Rezoning Transportation Analysis

Petition Number: Insert Zoning Petition #2021-239

Date	Description
02-18-2022	First Review (AO)
03-23-2022	Second Review (AO)

RZ-2

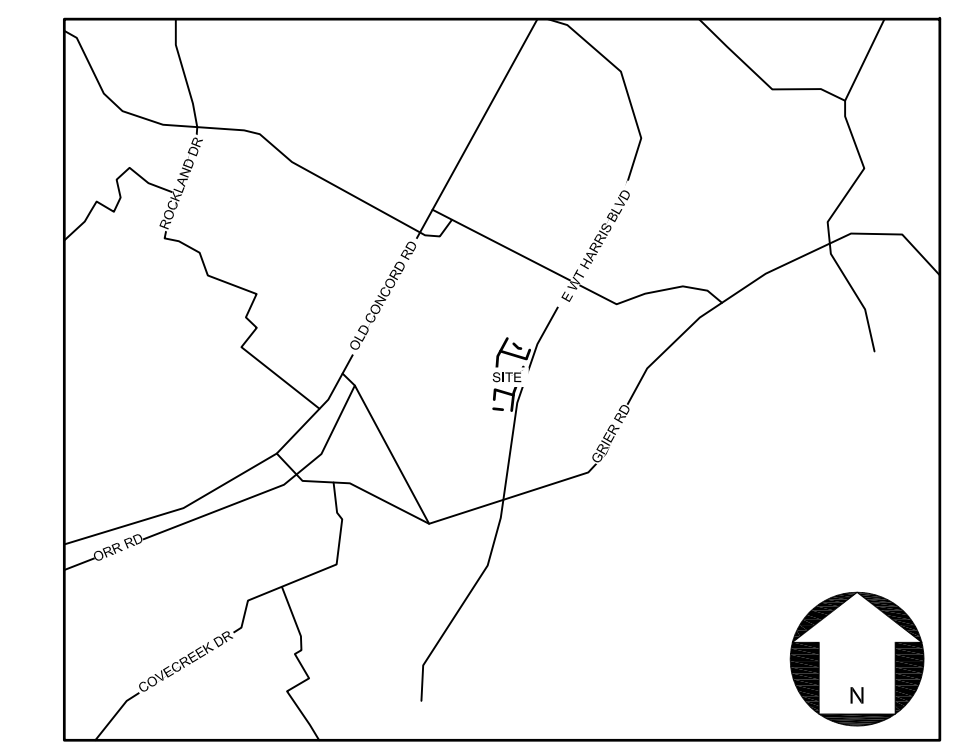
3. Revise site plan and conditional note(s) to commit to construct an 8-foot planting strip, and 6-foot sidewalk on District Dr per Chapter 19 / Chapter 20. The site plan shall label and dimension both items from the back of curb and gutter and road centerline.
Update to Comment (New Site Plan, 03-14-22): Add conditional note committing to constructing an 8-foot planting strip, and 8-foot sidewalk on District Dr and Shorthorn St as depicted on site plan.

- 10. **New Comment (Site Plan, 3-14-22):** Add conditional note(s) that all private alleys/ streets to meet all minimum horizontal and vertical design requirements.
